SITE DEVELOPMENT PLAN

Vertical sidebar containing: REVISIONS table, TAIT & ASSOCIATES logo and address, SITE DEVELOPMENT PLAN title, PROJECT NAME: HONOR CHARTER SCHOOL HIGHMARK SCHOOL DEVELOPMENT 8250 BENT GRASS MEADOWS DR., DRAWING NO., DATE, CHECKED, DATE, REVISION, DATE, JOB NO., and SHEET INDEX S-1 OF 48.

V1_Site Development Plan.pdf Markup Summary

S-1
OF
48

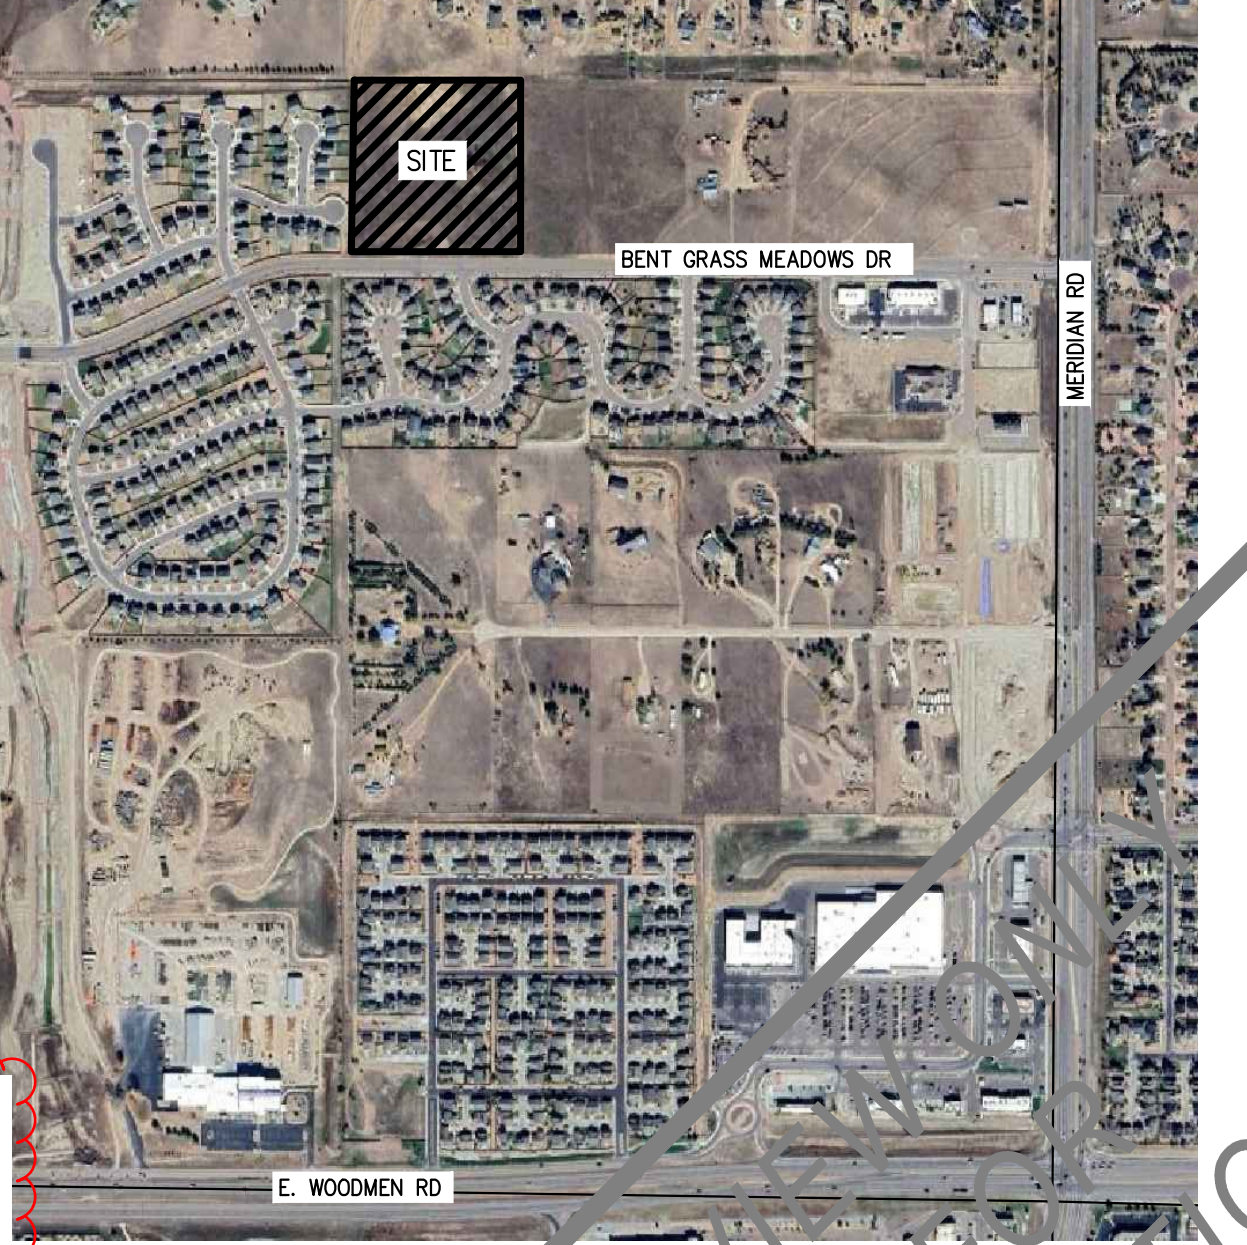
delete this as this when approved will be for construction

please update to 25-337

please update to
25-337

Please provide the parking plan and table on a sheet based on the Land Dev Code . Identify dimensions, ADA spaces, Loading/drop off areas, Bus Parking ; staff Parking (you will need both categories since you are 2 schools in one)

Show all property lines and depict 25 foot building setbacks per the checklist and provide landscape , buffer setbacks per Chapter 6

is there a chained Emergency access?

Please add site development plan checklist add missing items

depict the playground as it is to be approved with this site dev plan

what is this area? what is surface

is an opaque buffer screen wall provided adjacent to residential homes? a 15' buffer is required.

title block

delete this as this when approved will be for
constriction
